**RE: REPONSE TO REQUEST FOR FURTHER INFORMATION
BURRAH PARK (SSD-70316465)
1953 ELIZABETH DRIVE, BADGERYS CREEK, NSW**

The following memo provides additional information in response to the Request for Further Information (RFI) issued by Sydney Water for SSD-70316465 at 1953–2109 Elizabeth Drive, Badgerys Creek (ref 216284).

Appendix A - Register of pre-determination items

BASE PLAN:
240518_DA_C171 REV.03 by Henry & Hymas

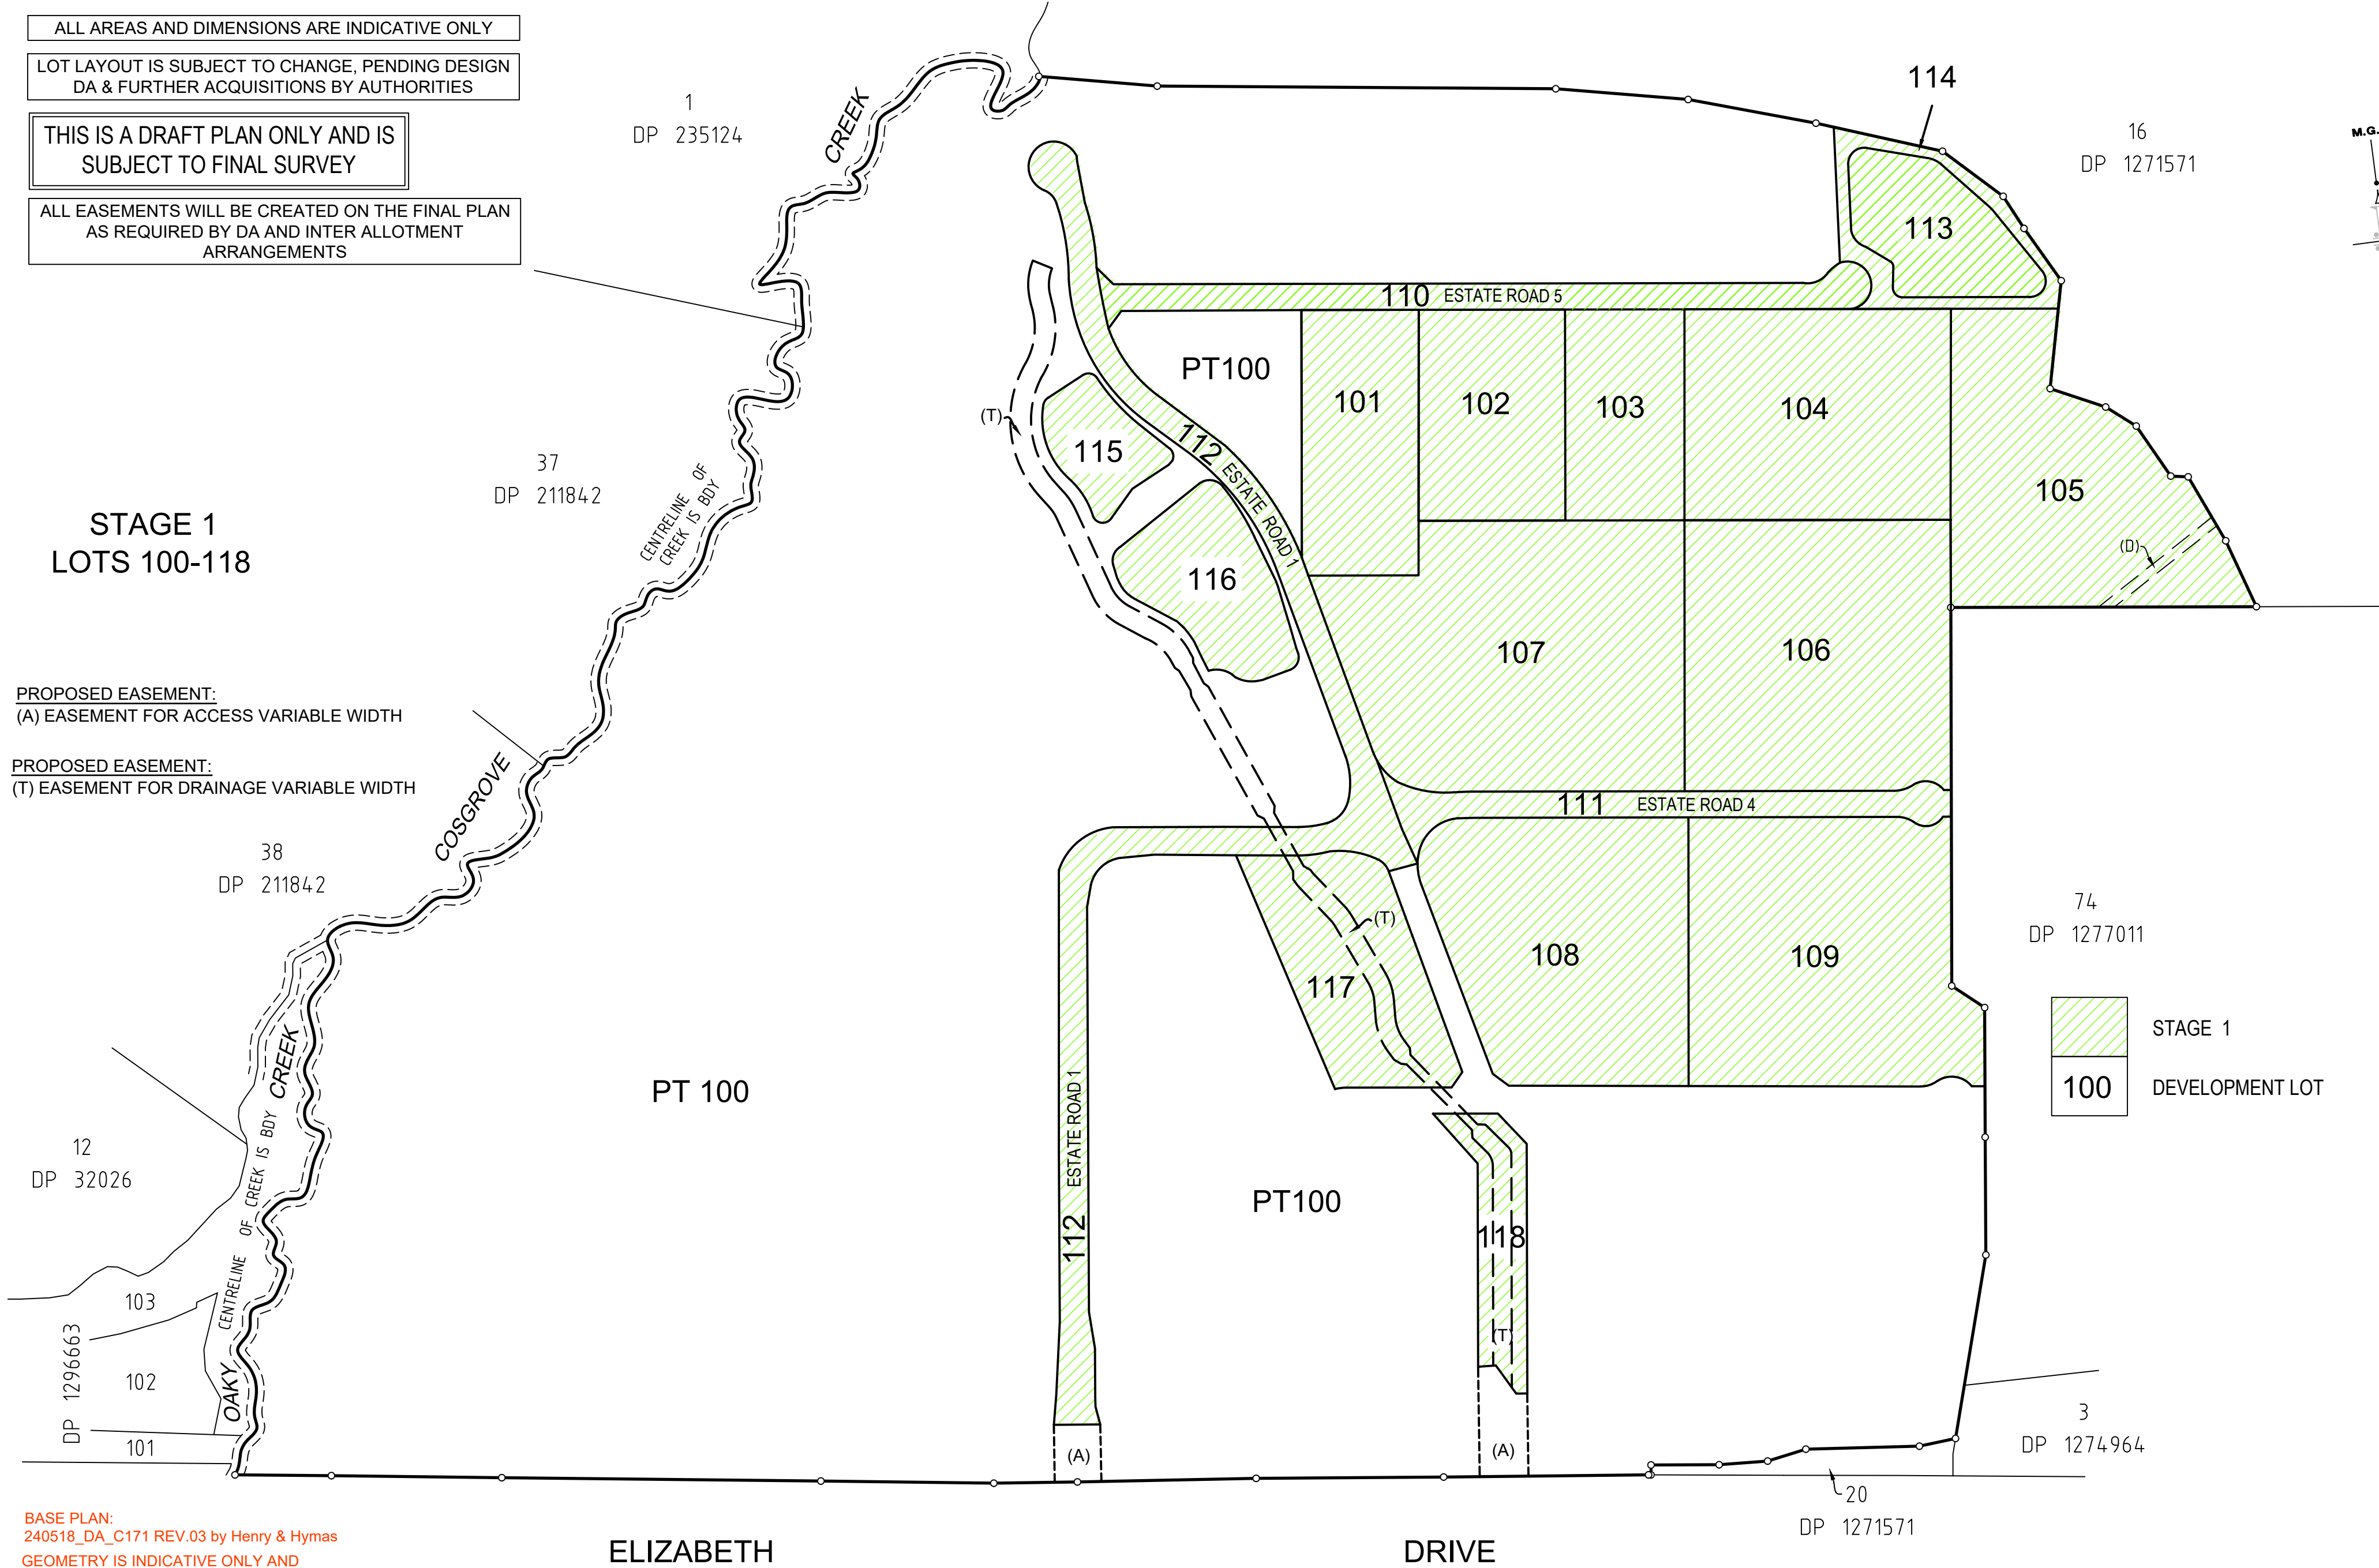
SWC Comment	Applicant Response	To be addressed	Sydney Water Response	Applicant Response 2
<p>1. SSD 70316465 scope clarification:</p> <p>1. Cut and fill for all the stormwater basins to be included</p> <p>2. Construction of only stormwater infrastructure C12, C13 and C15, including pumps, pipes, pits, liners, culverts, access track, plant palette, etc</p> <p>3. Construction of the central trunk drainage from Elizabeth drive to strata 2 creek, next to M12 and Cosgrove's Creek intersection.</p> <p>4. Appendix O - Civil Engineering Report p.8 a. Warehouse 1.1, 1.2 and 3.1 are part of stage2 not stage 1</p>	<p>1. Cut and filling is required to form the stormwater basin network and may form part of SWC assessment. The earthwork for the stormwater basins is included as per the overlay earthworks strategy for the estate and is detailed on drawings BE01-BE31 and civil engineering report – Chapter</p> <p>1.2,1.3,1.4, As outlined in the civil engineering report and drawings we are seeking approval for all basin and related infrastructure for the estate works associated with the Burrah Park Concept Plan. Basins CC10-CC15. During SWC recent feedback session and previous coordination sessions the scope has been clarified in detail (difference between planning stage and project staging). The scope of the works seeking approval has not changed and has not been raised in previous RFIs. Naming convention can be adjusted as required to provide further clarity (if required).</p> <p>1.5. Correct, part of the Stage 1 estate road catchment bypasses treatment during stage 1 and is later drained to basin CC14 constructed as part of stage 2. This is to allow for construction sequencing of central drainage channel and Basin CC14 and CC12. It should be noted that Stage 1 stormwater management system achieves water quality and flow targets with the inclusion of R.D.1.S1 bypass.</p> <p>b. Please correct document to include the right warehouses number as documented in Appendix S Detailed Staging Plan</p> <p>5. Note that run-off from road R.D.1.S1 is not treated by any regional stormwater infrastructure in stage 1.</p>	<p>Clarification item.</p> <p>Add additional comments to delineate approval vs. project staging to be included in pre-determination package.</p>	<p>N/A</p> <p>N/A</p> <p>Agree - pre-determination</p>	<p>Refer Chapters 1.0, 3.1 and 3.2 of revised engineering report. Further clarification provided regarding staging delineation.</p> <p>A Temporary GPT is proposed in Stage 1 to treat catchment R.D.1.S1. Refer C171.</p>
